# Response to Submissions Documentation

## Waterloo South

Revision B

21 August 2026

Proposed CSSDA **RtS** LEP Amendments - Height of Building.

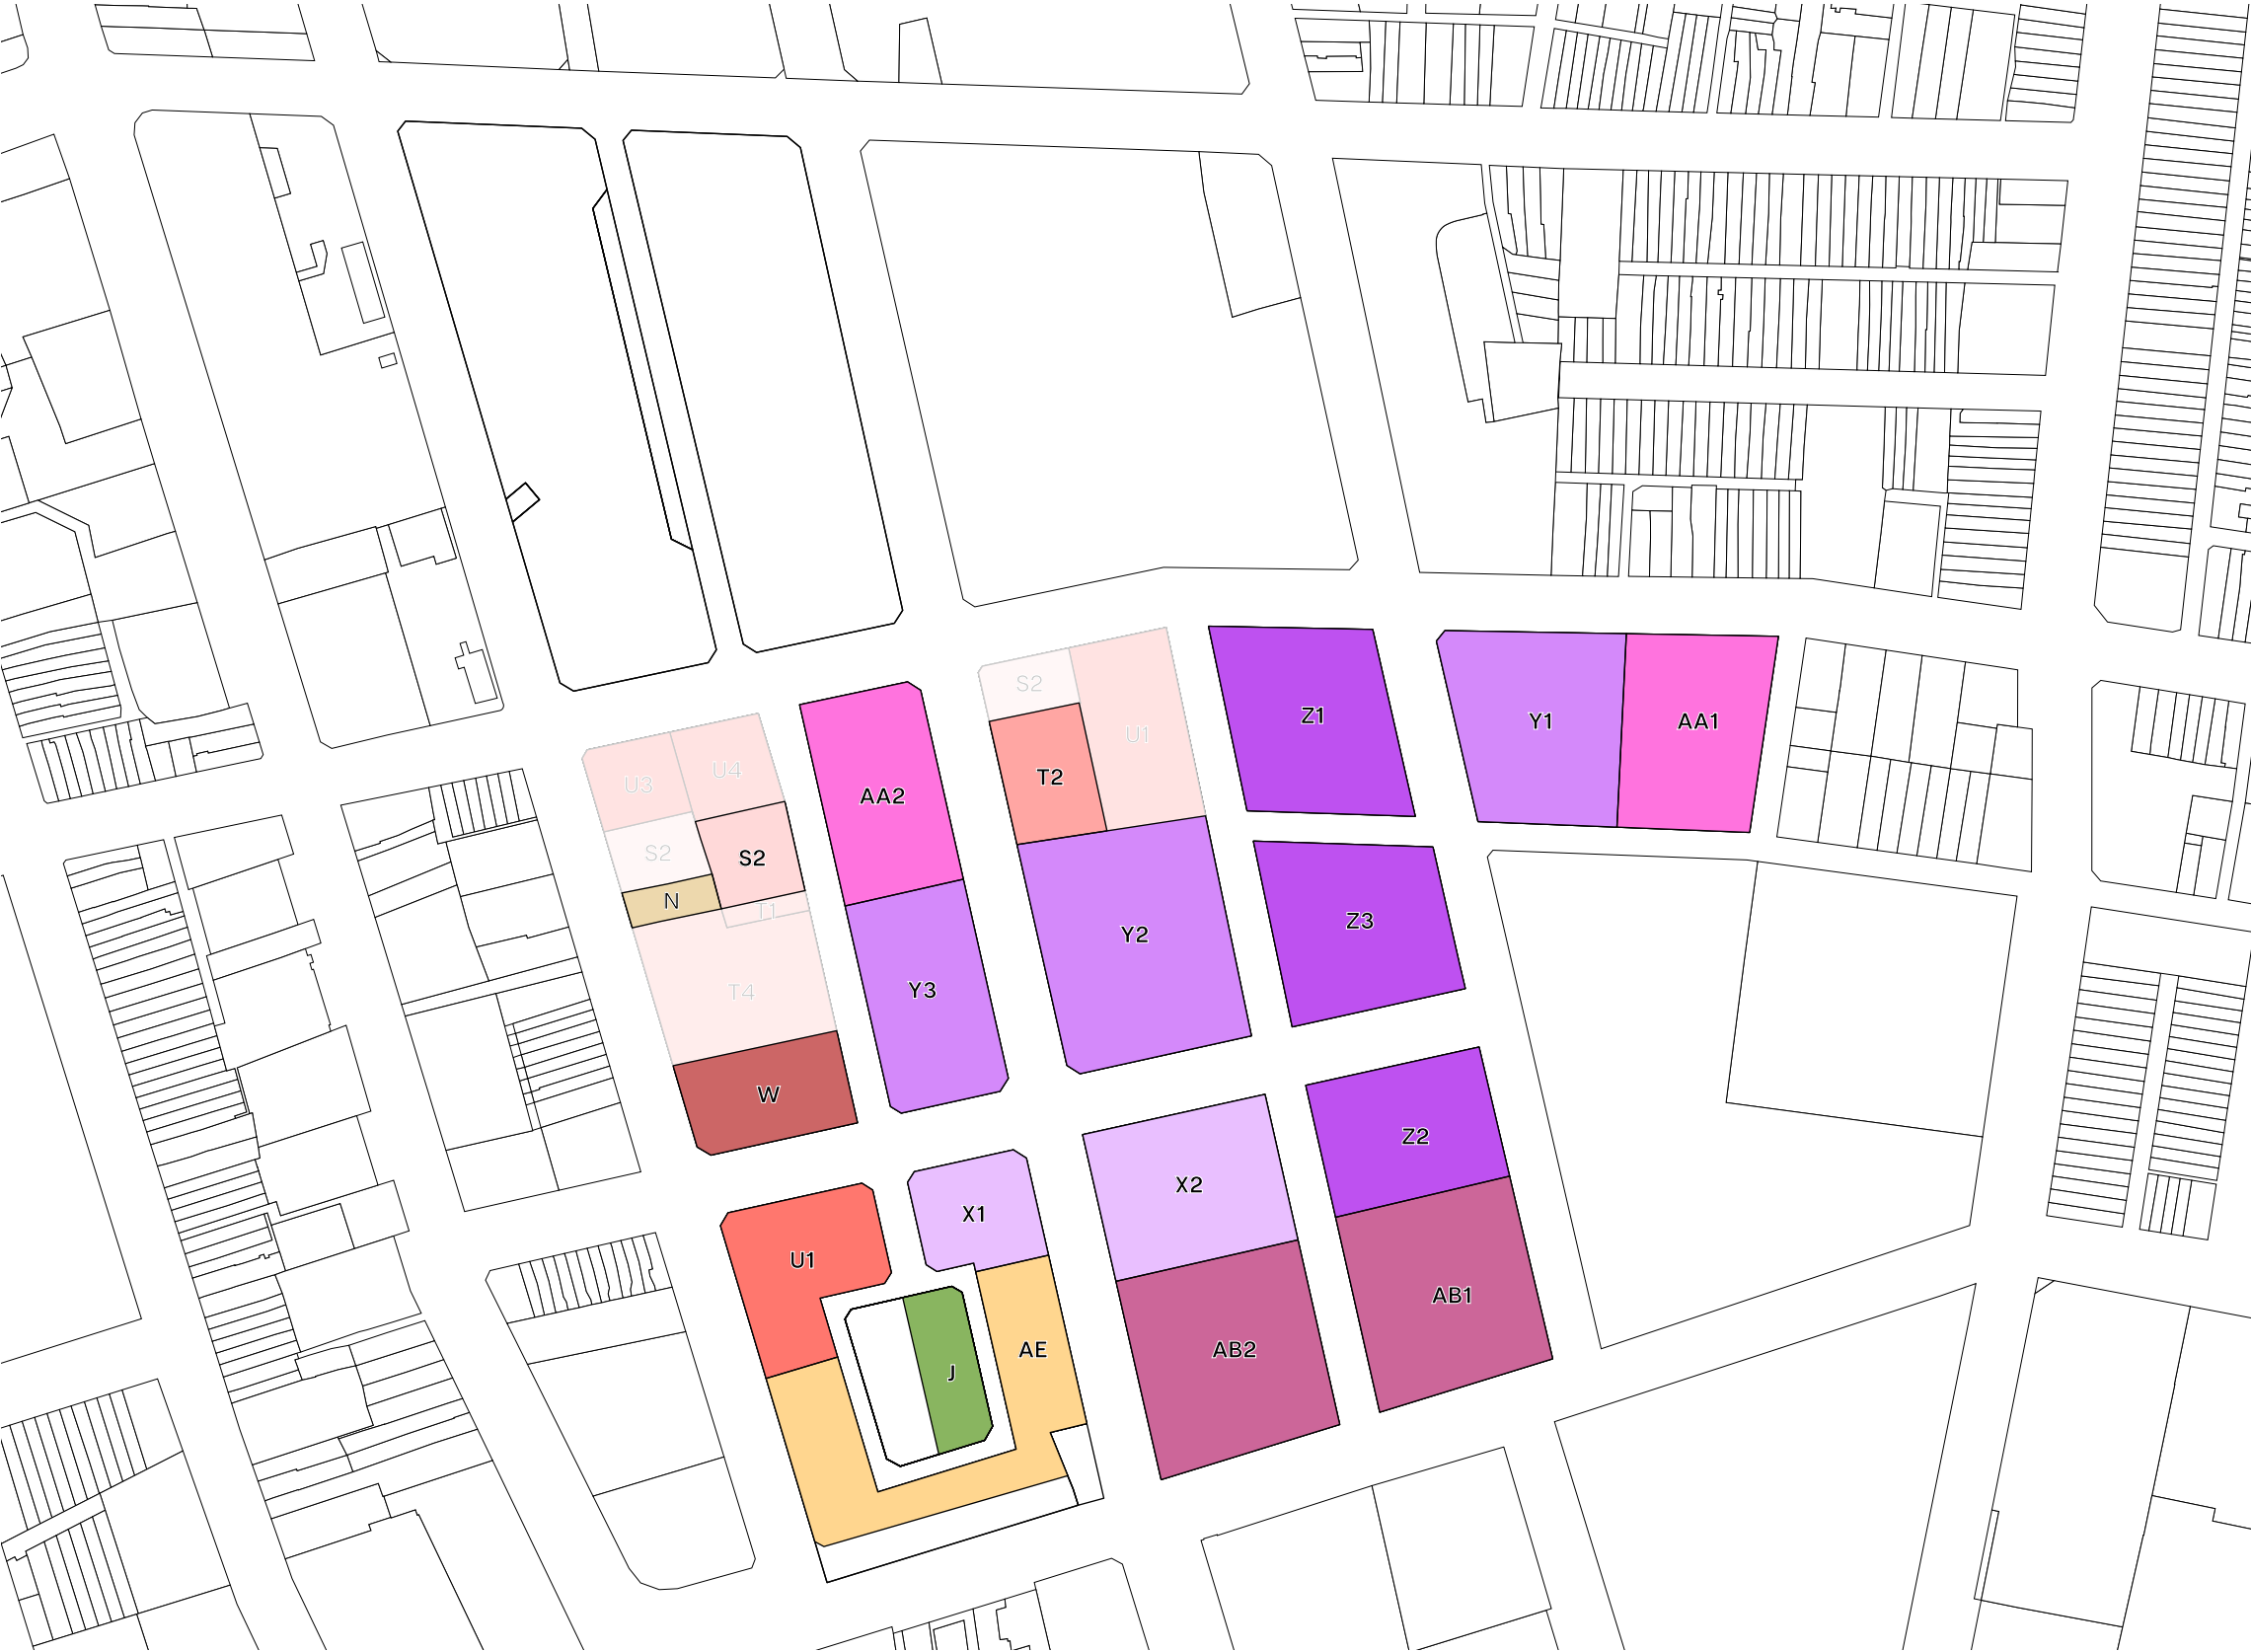
| Agency                                |  | Summary of Key Issues                                                                                                                                                                                                                                                                                                                                                                                                                                                                                                                                                                                                                                                                                                                                                                                                                                                                                                                                                                                                                                                                                                                                                                                                                                                                                                                                                                                              | Response                                                                                                                                                                                                                                                                                                                                                                                                                                                                                                                                                                                                                                           | Supporting RtS Documentation |
|---------------------------------------|--|--------------------------------------------------------------------------------------------------------------------------------------------------------------------------------------------------------------------------------------------------------------------------------------------------------------------------------------------------------------------------------------------------------------------------------------------------------------------------------------------------------------------------------------------------------------------------------------------------------------------------------------------------------------------------------------------------------------------------------------------------------------------------------------------------------------------------------------------------------------------------------------------------------------------------------------------------------------------------------------------------------------------------------------------------------------------------------------------------------------------------------------------------------------------------------------------------------------------------------------------------------------------------------------------------------------------------------------------------------------------------------------------------------------------|----------------------------------------------------------------------------------------------------------------------------------------------------------------------------------------------------------------------------------------------------------------------------------------------------------------------------------------------------------------------------------------------------------------------------------------------------------------------------------------------------------------------------------------------------------------------------------------------------------------------------------------------------|------------------------------|
| City of Sydney                        |  | <p><u>Height of Building</u></p> <p>Height controls are generally reflective of the concept plan but are too coarse. If the proposed concept envelopes and reference schemes are to demonstrate that future developments are capable of complying with the proposed controls, the proposed heights appear significantly more generous than the maximum yield. In particular, on some sites where there is a 40m difference in height between the LEP control and the reference scheme height.</p>                                                                                                                                                                                                                                                                                                                                                                                                                                                                                                                                                                                                                                                                                                                                                                                                                                                                                                                  | <p>The revised LEP Height of Buildings controls respond to City of Sydney feedback seeking closer alignment between the planning envelopes and statutory height controls. Amendments are proposed for Buildings 4C, 5A, 6A and 8A, while no changes are proposed for Buildings 2D, 9B and 10A. Retention of the existing controls for Buildings 2D, 9B and 10A is necessary to support ADG compliance, maintain design flexibility and uphold the intended built form outcomes for the precinct.</p> <p>Refer to the supporting RtS documentation for detailed justification of the proposed LEP height amendments.</p>                            | Pg 15 - 21                   |

This page presents the revised LEP Height of Buildings controls in response to the City of Sydney’s EIS feedback, which sought closer alignment between the planning envelopes and the proposed LEP height controls. The table on the right identifies the amendments proposed for Buildings 4C, 5A, 6A and 8A. The revision also responds to removal of TfNSW’s registered titles along McEvoy Street.

**Building 2D**  
No change is proposed to the 37m height control. A reduction in height would further constrain the delivery of compliant apartment layouts, particularly given the challenges associated with south-facing aspects and achieving ADG outcomes.

**Building 9B**  
No change is proposed to the 56m height control. Retaining this height provides flexibility for future Stage 1 design development while maintaining the strategic intent of concentrating height along George Street.

**Building 10A**  
No change is proposed to the 39m height control. The podium component of Building 10A is approximately 35m in height, and it is unclear how the 25m height referenced in Council’s submission was derived.

Figure 1824: Carpark locations and entries

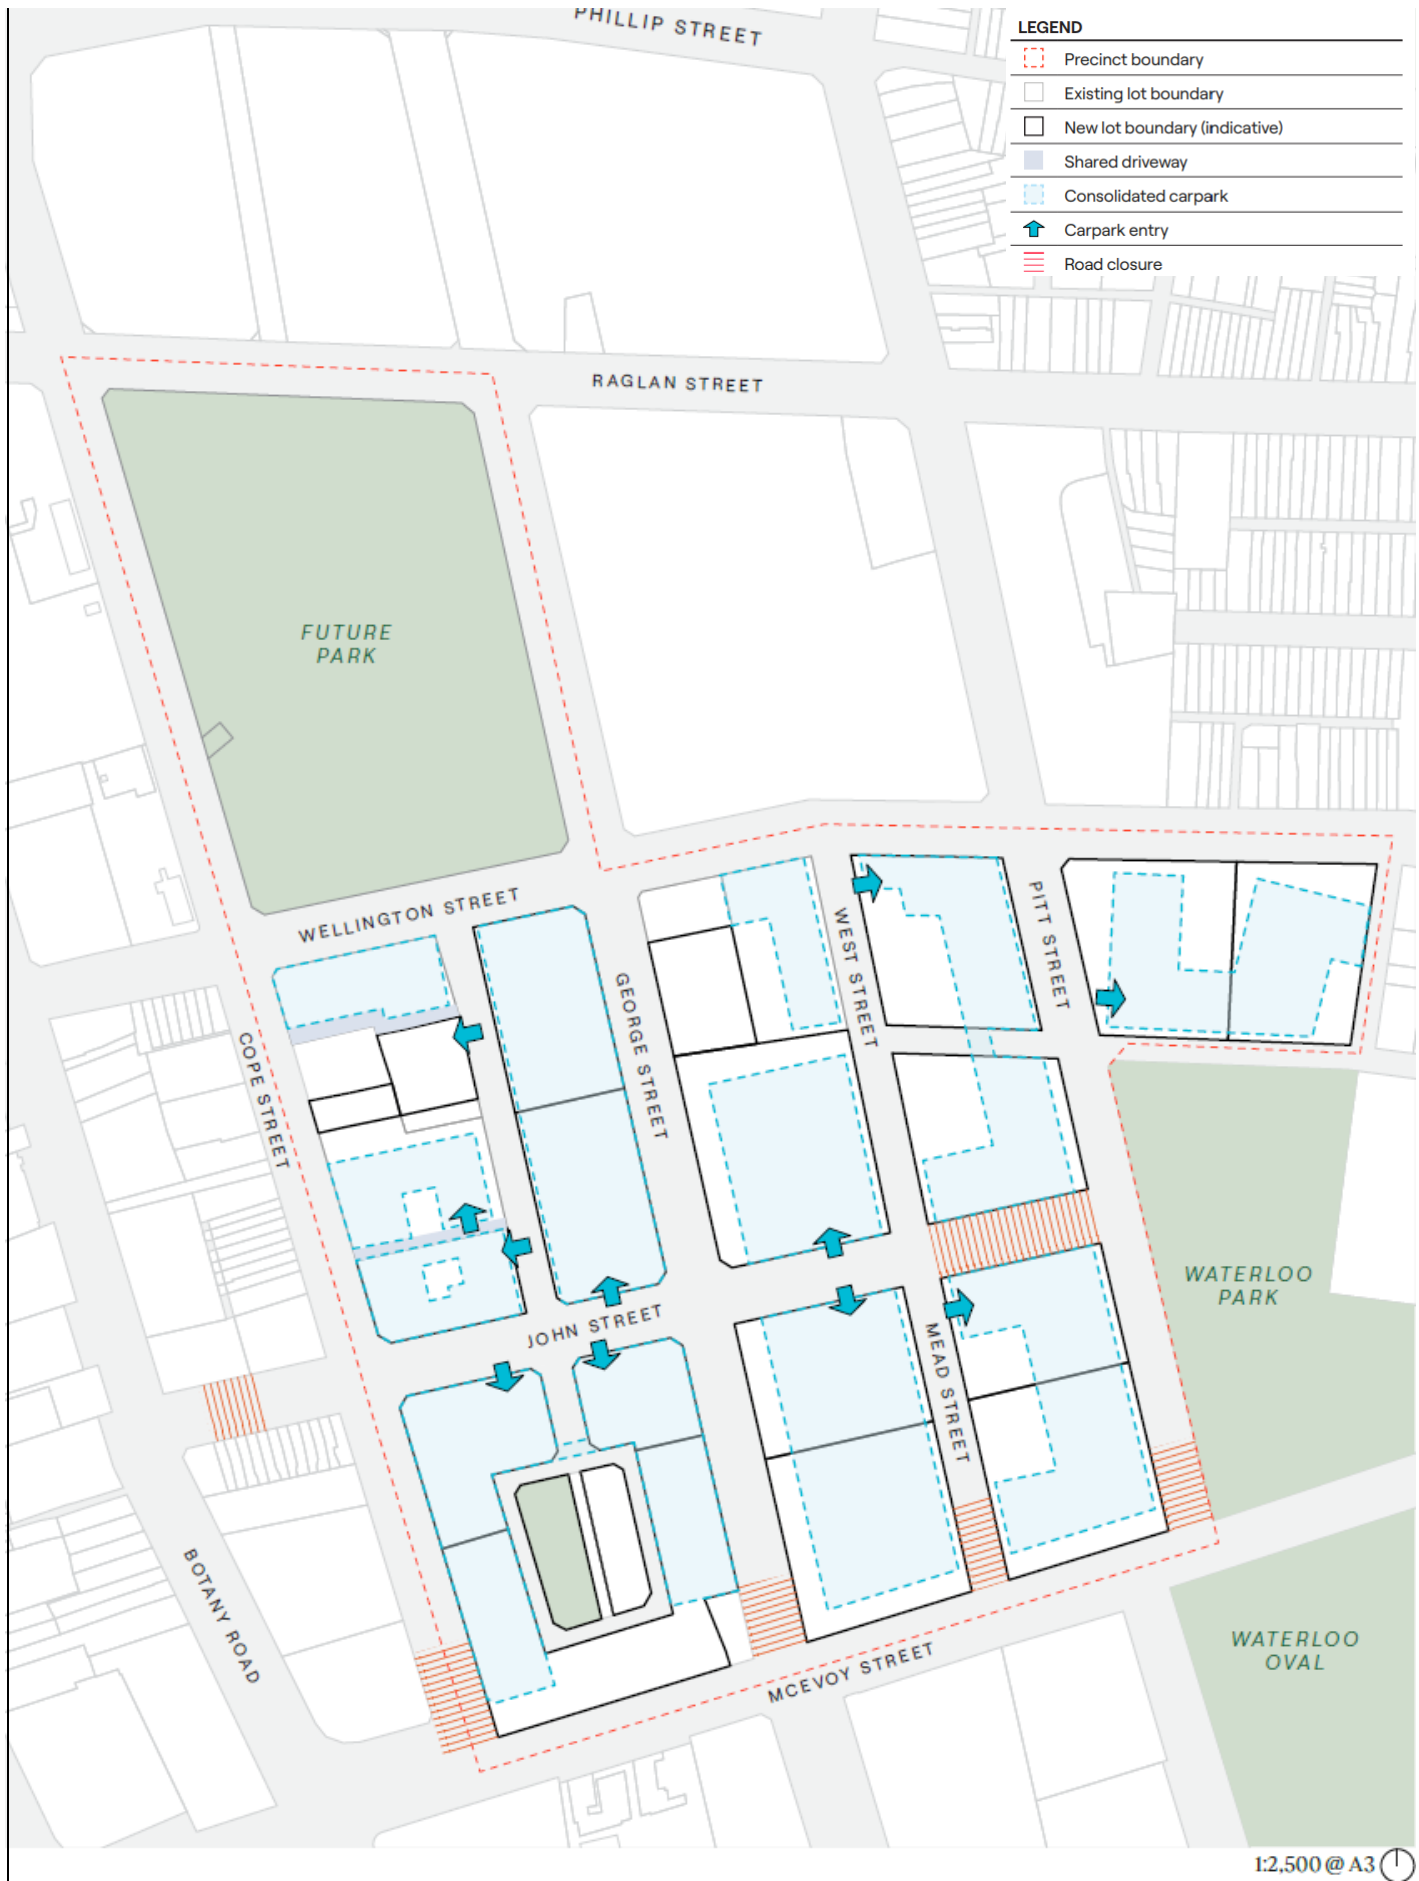
| Agency                   | Summary of Key Issues                                                                                                                                                                                                                                                                                                                                                                                                                                                                                                                                                                                                                                                                                                                                                                                                                        | Response                                                                                                                                                                                                                                                                                                                                                                                                                                                                                                                                                                                                                                                                                                                                                   | Supporting RtS Documentation |
|--------------------------|----------------------------------------------------------------------------------------------------------------------------------------------------------------------------------------------------------------------------------------------------------------------------------------------------------------------------------------------------------------------------------------------------------------------------------------------------------------------------------------------------------------------------------------------------------------------------------------------------------------------------------------------------------------------------------------------------------------------------------------------------------------------------------------------------------------------------------------------|------------------------------------------------------------------------------------------------------------------------------------------------------------------------------------------------------------------------------------------------------------------------------------------------------------------------------------------------------------------------------------------------------------------------------------------------------------------------------------------------------------------------------------------------------------------------------------------------------------------------------------------------------------------------------------------------------------------------------------------------------------|------------------------------|
| City of Sydney Community | <u>Vehicle Access Locations</u><br>There are some inconsistencies between the submitted Transport Study and the Design Guide. The Transport Study does not show a vehicle access into Block 4A from West St, while the latter does. Additionally, the Transport Study does not show access into 2A, 2B or 2E, while Design Guide shows two access points. This should be clarified in documentation                                                                                                                                                                                                                                                                                                                                                                                                                                          | <a href="#">Car park entries servicing the private lots within Blocks 4A, 2A and 2E have been removed from the amended Design Guide map. PTC will update the Transport Study to illustrate an indicative 6m-wide access arrangement to Block 2B from Cooper Street. As no basement is proposed for Block 2B, a vehicle entry is not required.</a><br><br><a href="#">The Block 8 basement footprint has also been revised to align with the Stage 1 design. The basement is now configured as two separate structures, connected via a services tunnel beneath Cooper Street. An additional car park entry providing access into 8BB1 will be added in the Design Guide.</a>                                                                               |                              |
